BCA ASSESSMENT REPORT

**Yiribana Logistics Estate, Kemps Creek
Warehouse 1 & 3 (Stage 1)**

**Prepared For:
The GPT Group**

Date: 04 July 2022

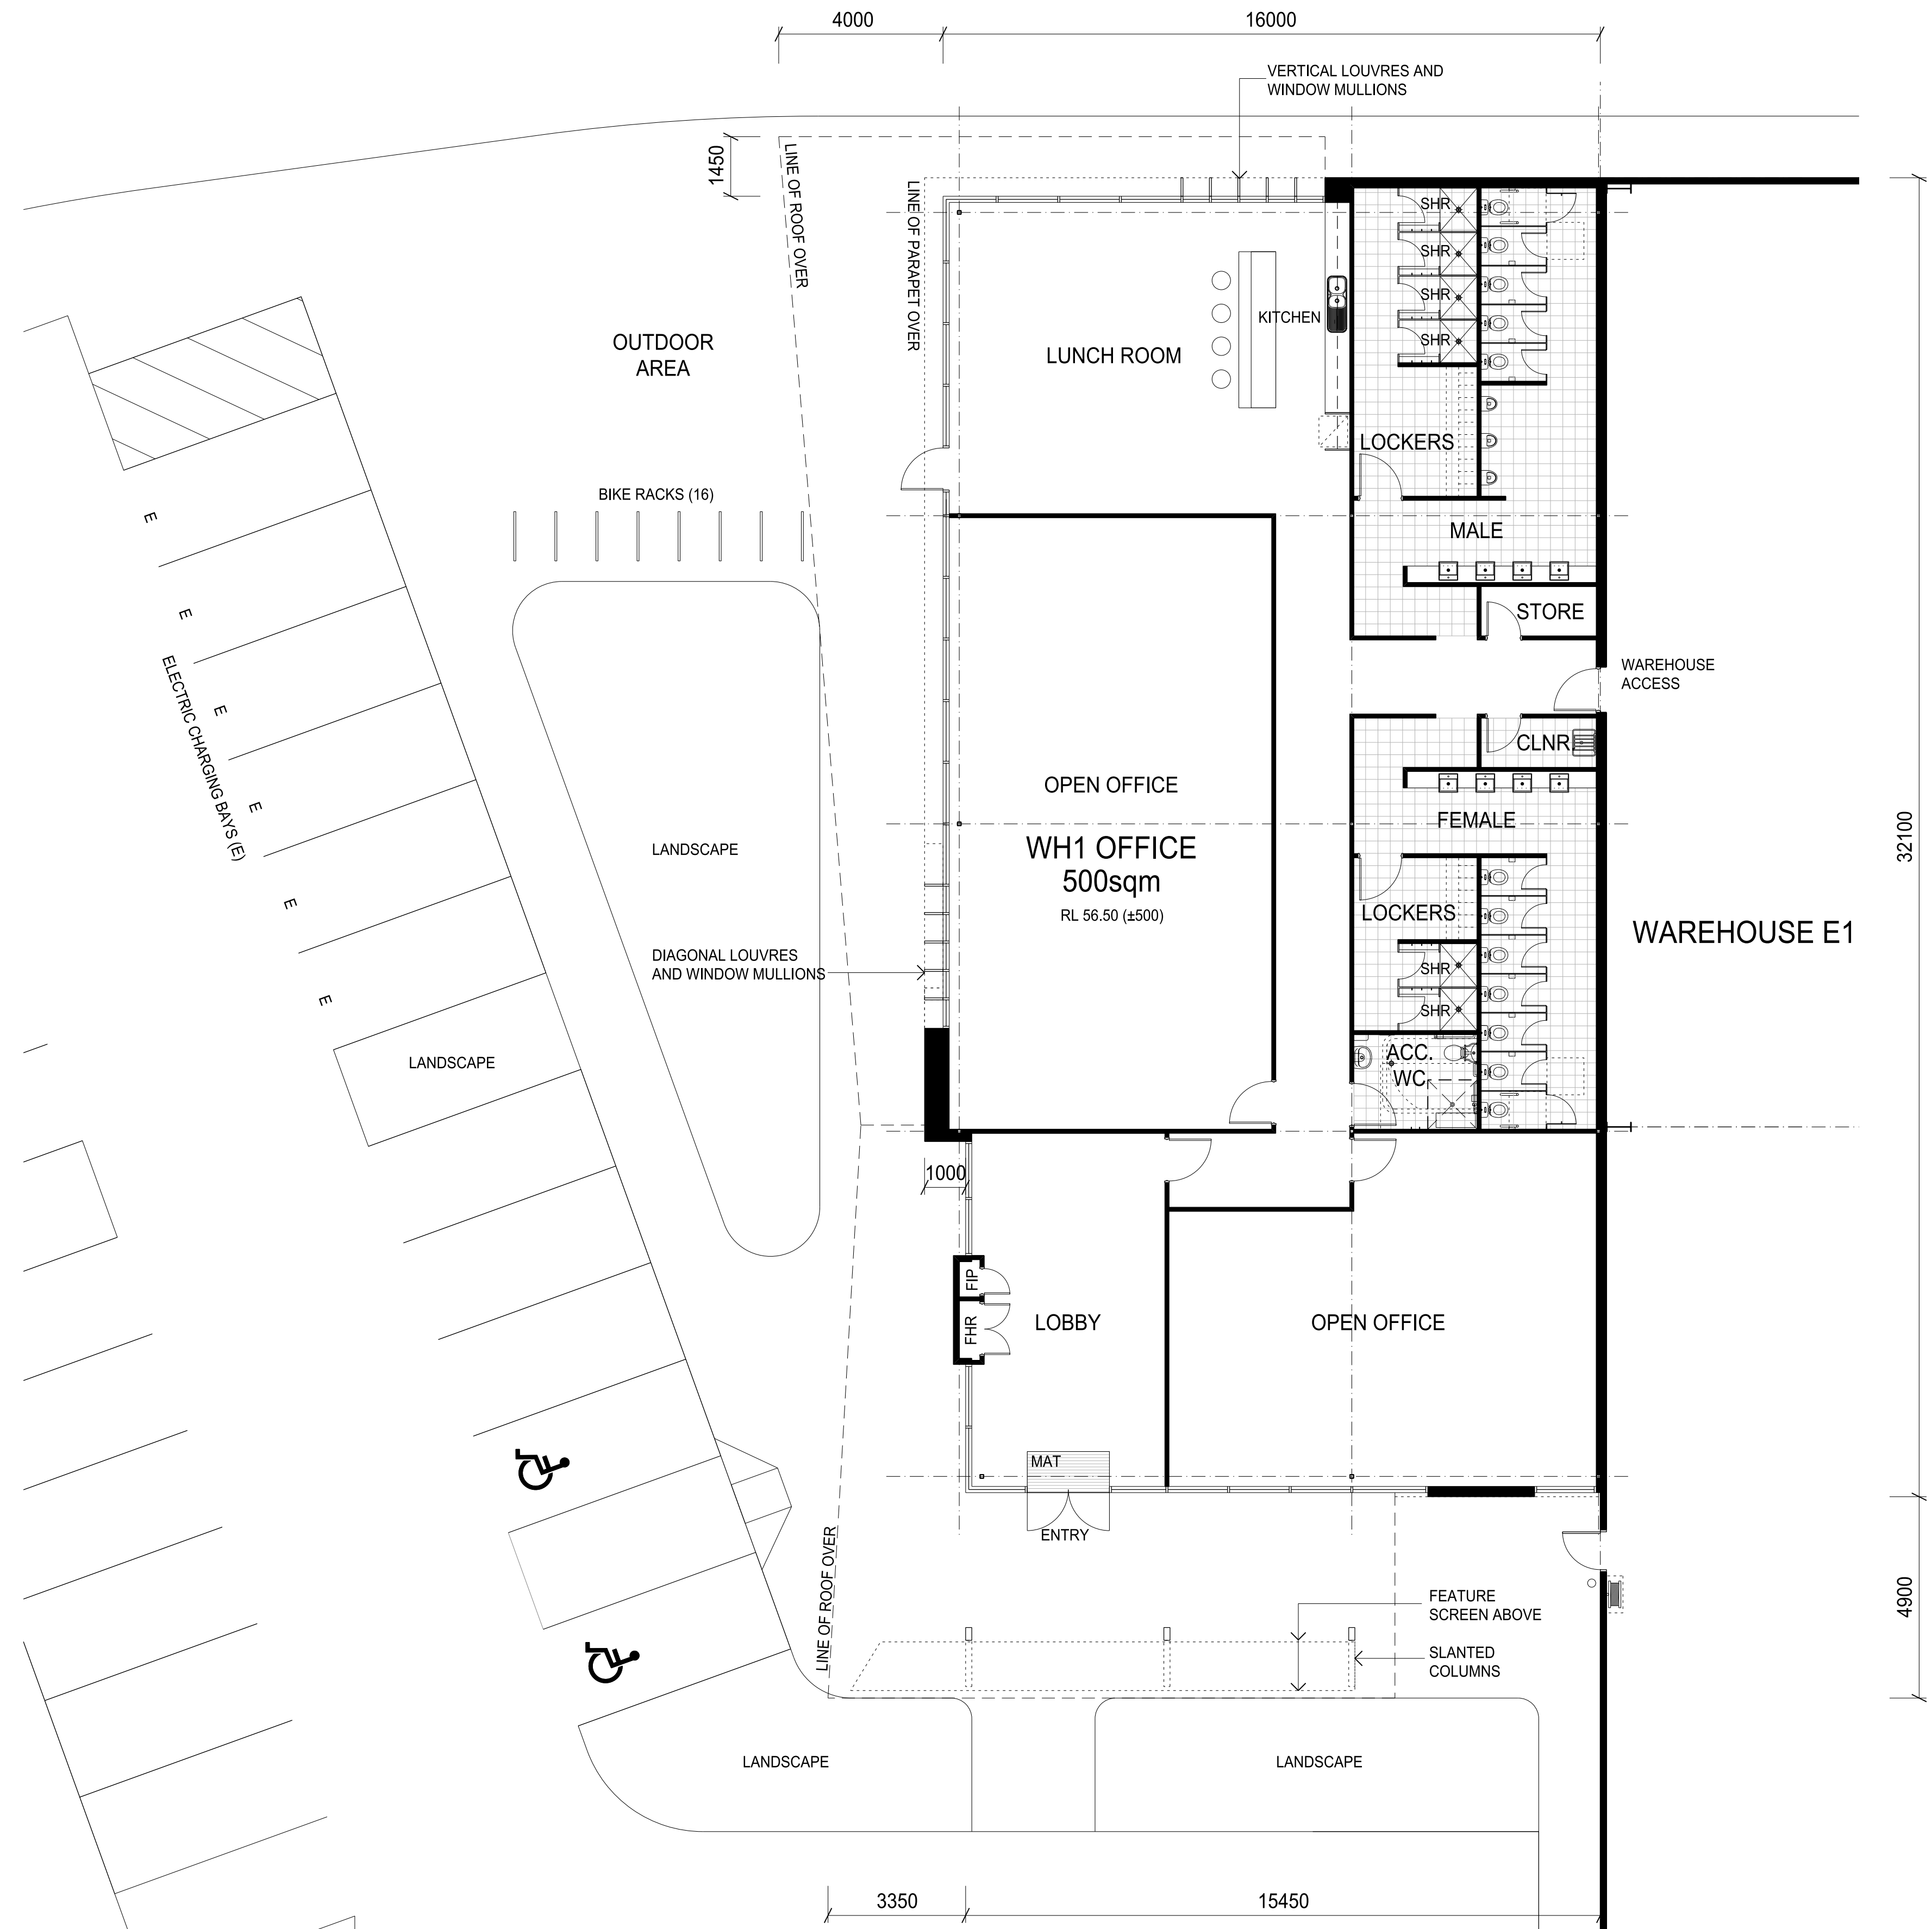
- + Perimeter Vehicular Access is greater than 18m from the external walls along the western side of the building, along the southern side of the warehouse at the recessed docks and in the south-eastern corner near the sprinkler tank & pump room – refer below mark-up:

Comments: The proposed Warehouse buildings do not comply with the provisions of C2.4 and thus the following non-compliance issues are required to be addressed as a Performance Solution by the Fire Engineer to demonstrate compliance with Performance Requirement CP9:

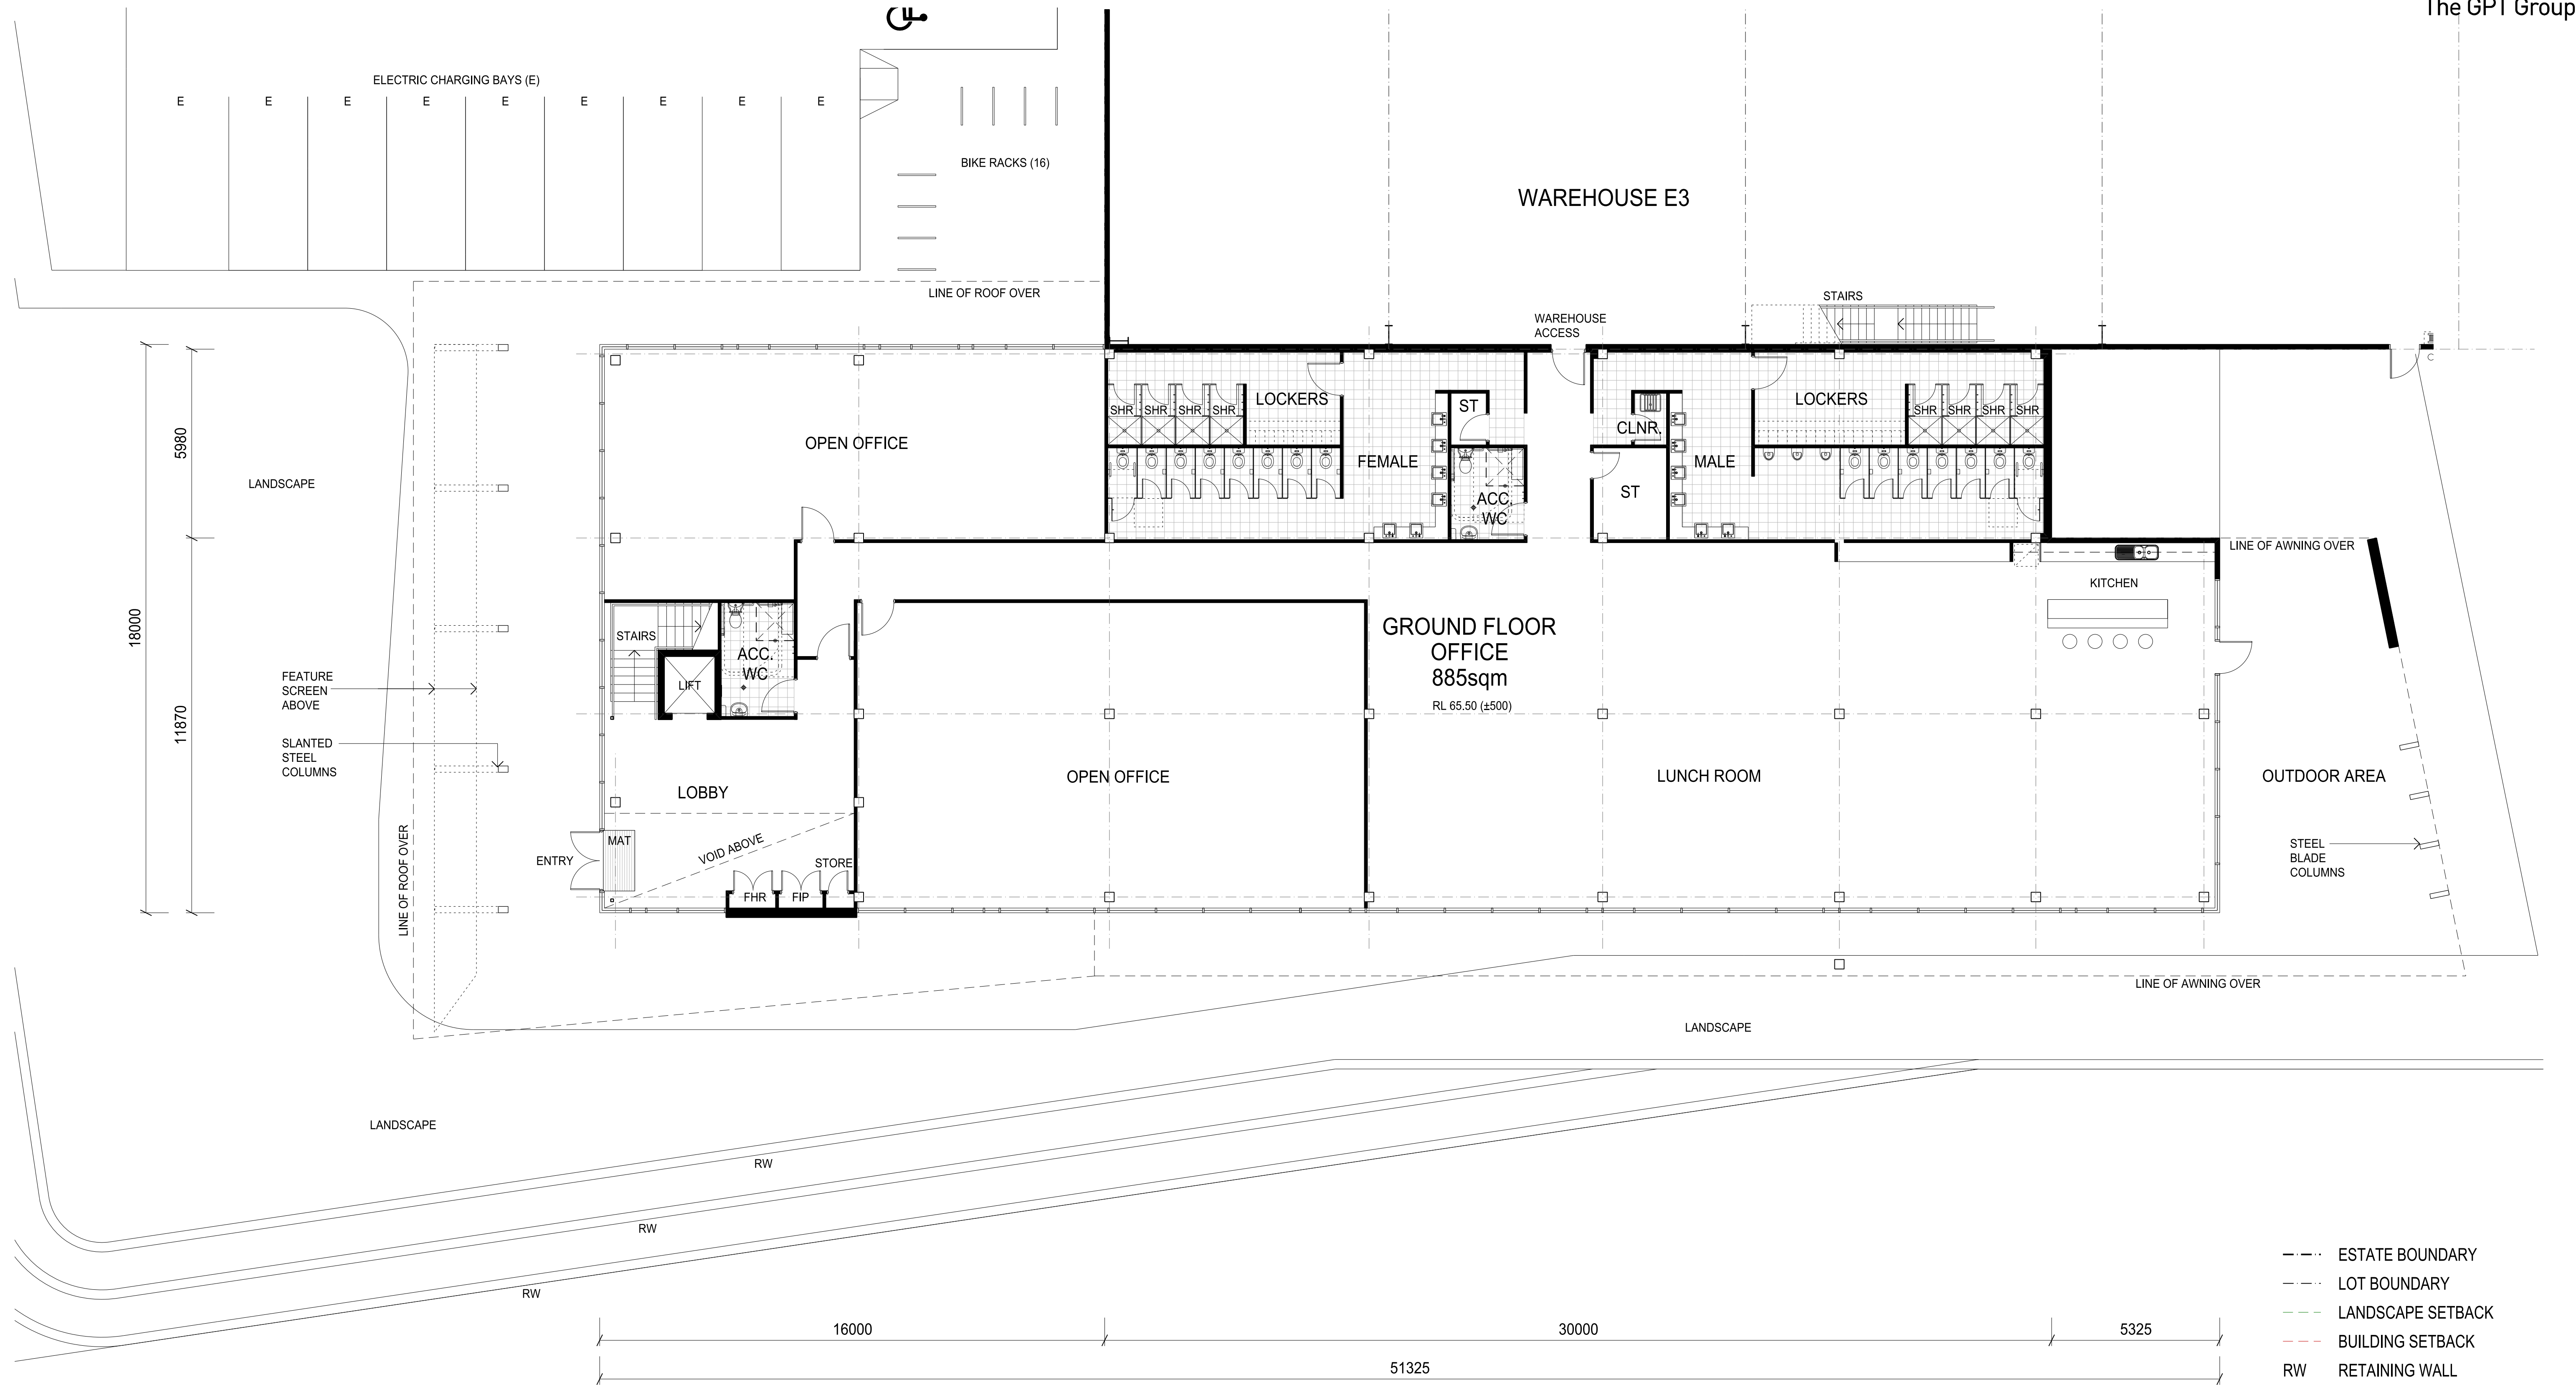
- + Perimeter Vehicular Access is greater than 18m from the external walls along the northern and western side of the building, along the southern side of the warehouse at the recessed docks and near the sprinkler tank & pump room – refer below mark-up. Additionally, consideration will need to be given to when the future road to the northern side of the warehouse will be completed, and any potential impacts on the below assessment if the road is not completed before an Occupation Certificate is required for the warehouse. Any temporary arrangements will need to be considered in the Performance Solution.
